Arun District Council
Arun Civic Centre
Maltravers Road
Littlehampton
West Sussex BN17 5LF
Planning & Building Control General Enquiries
Tel: (01903) 737756 Fax: (01903) 730442
Dx: 57406 Littlehampton
Minicom: 01903 732765
e-mail: planning@arun.gov.uk
website: www.arun.gov.uk/planning

Application No: CM/18/21/PL
Site Address: Land adj Mistletoe Farm Horsemere Green Lane Climping BN17 5QZ
Description of works: Erection of 1 No. 3 bed dwelling. This application is within CIL Zone 3 and is CIL liable as new dwelling.

Thank you for your internet representation made on 16th May 2021 which has been recorded as an objection with the comments as follows:

sheet 2 of 3

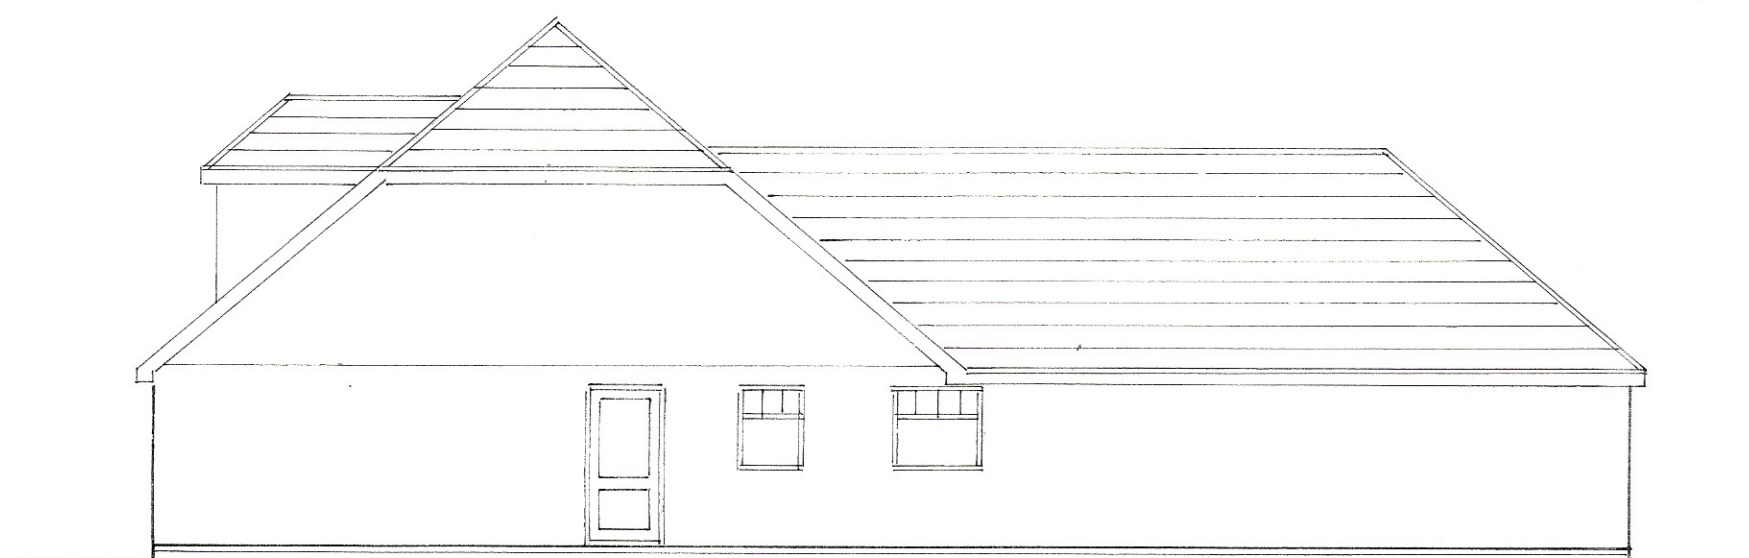
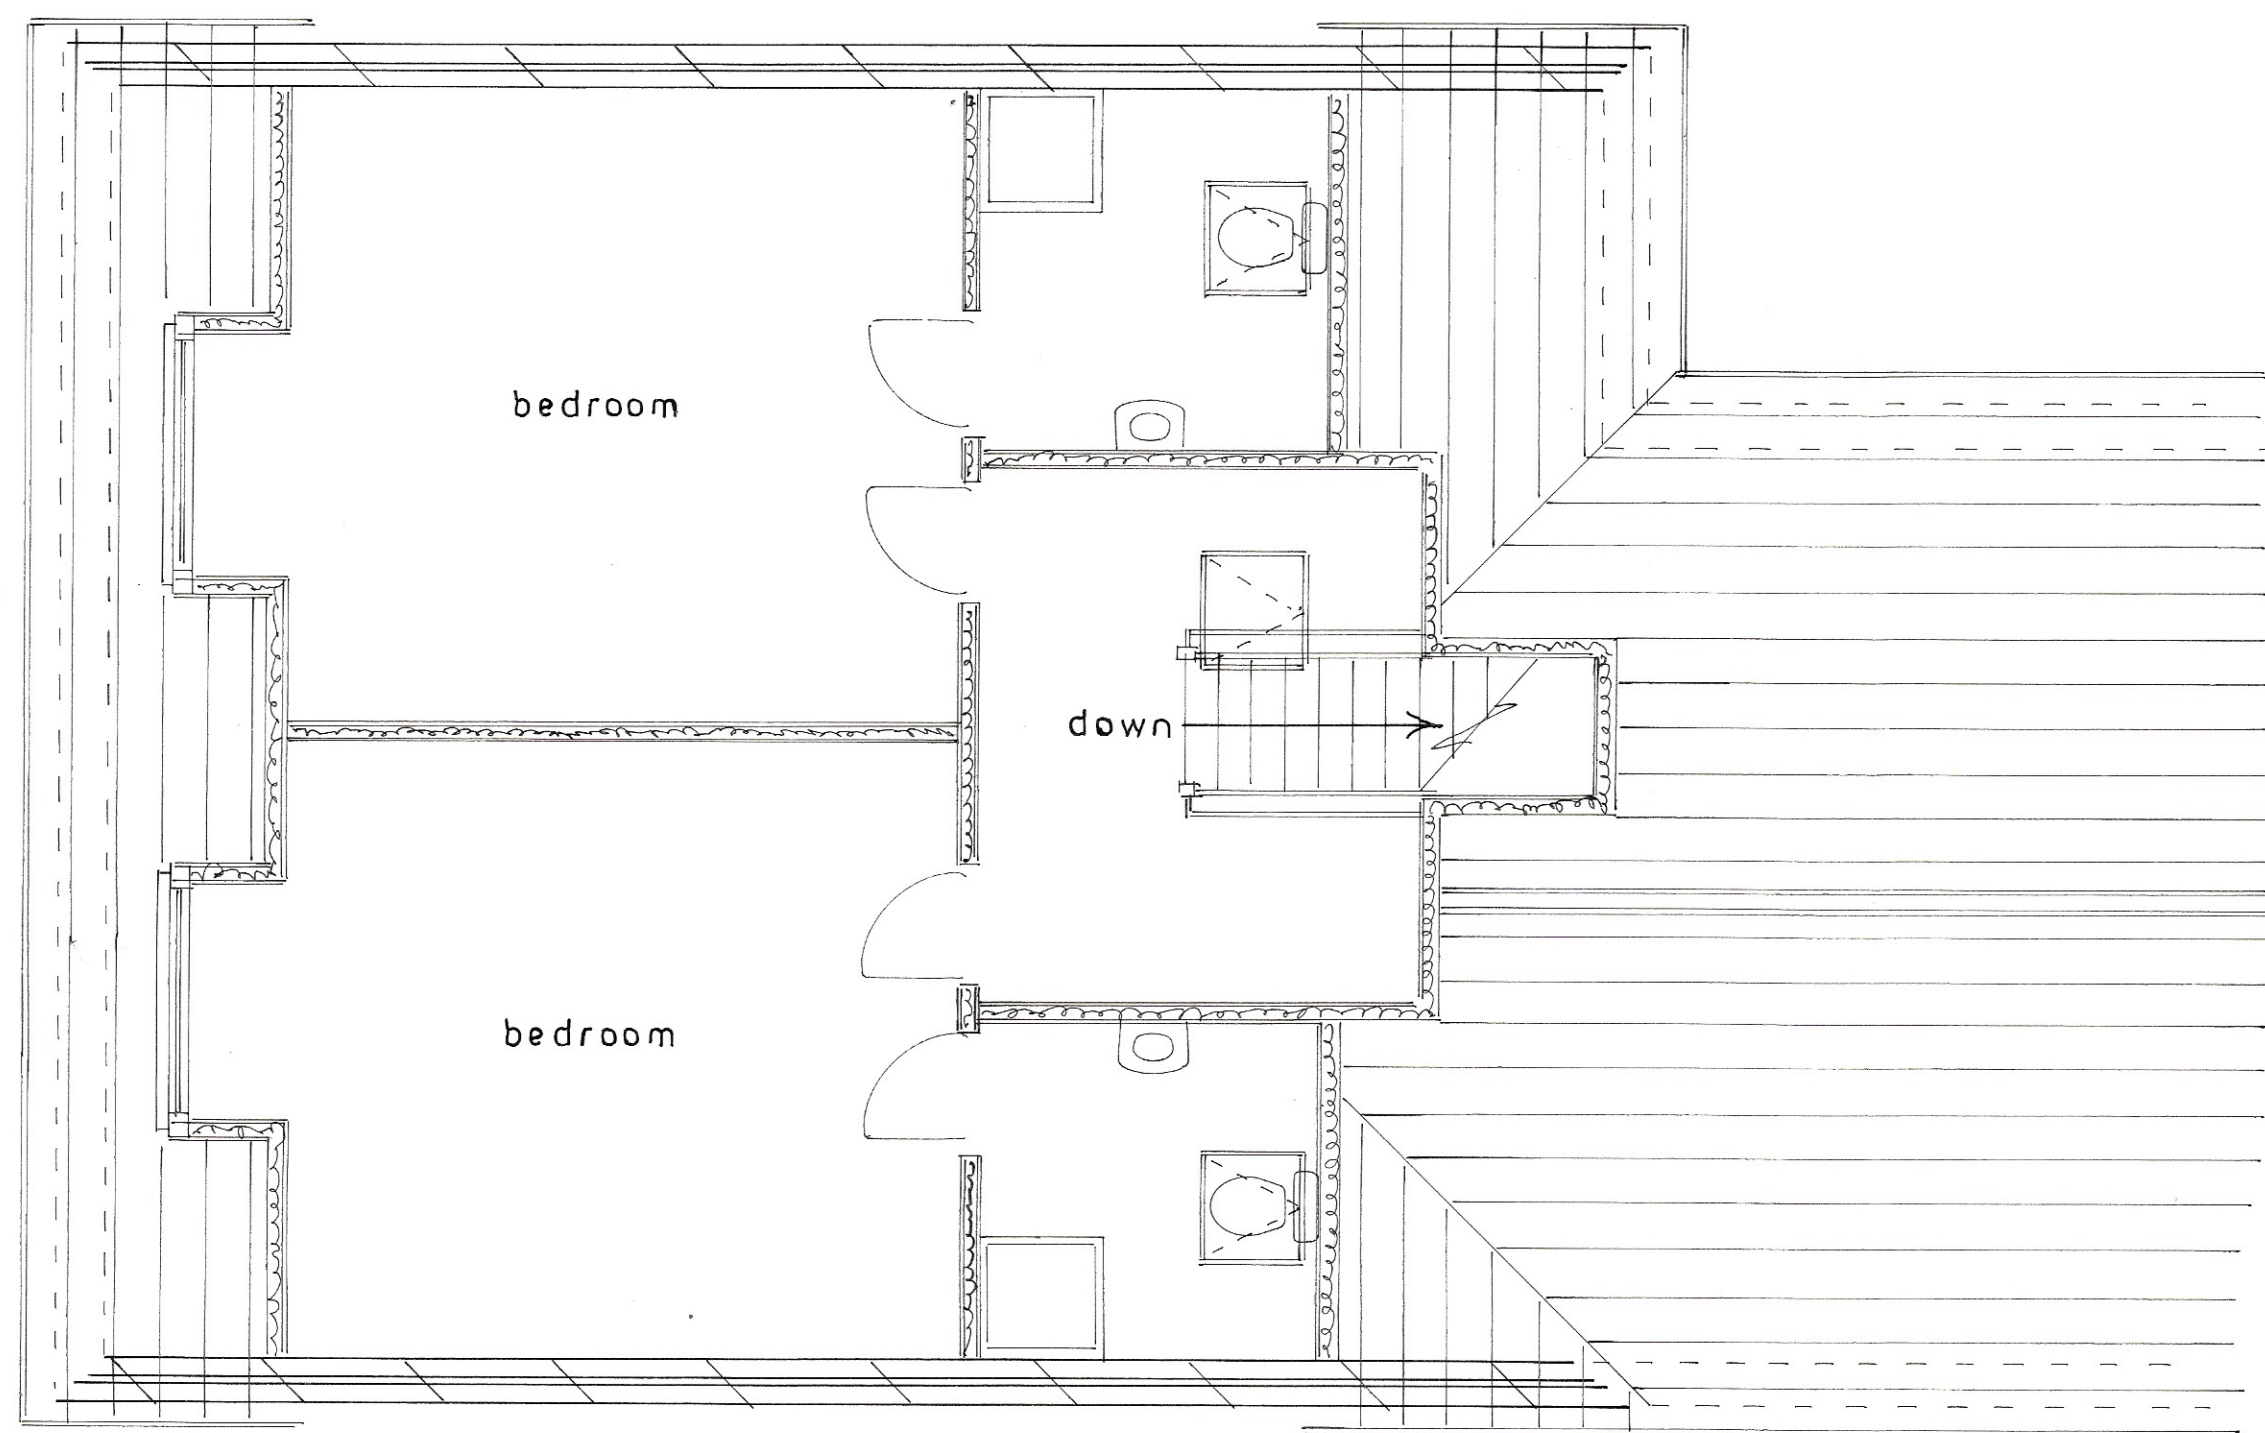
A two story dwelling on this site is out of character with the adjacent properties, as Mistletoe Farm, Sweet Briars and the properties in Wooldridge Walk are all single story.
Approving this application as it stands will be visually overbearing and is likely to impact on the privacy of the residents living in the adjacent bungalows in Wooldridge Walk and Mistletoe Farm.
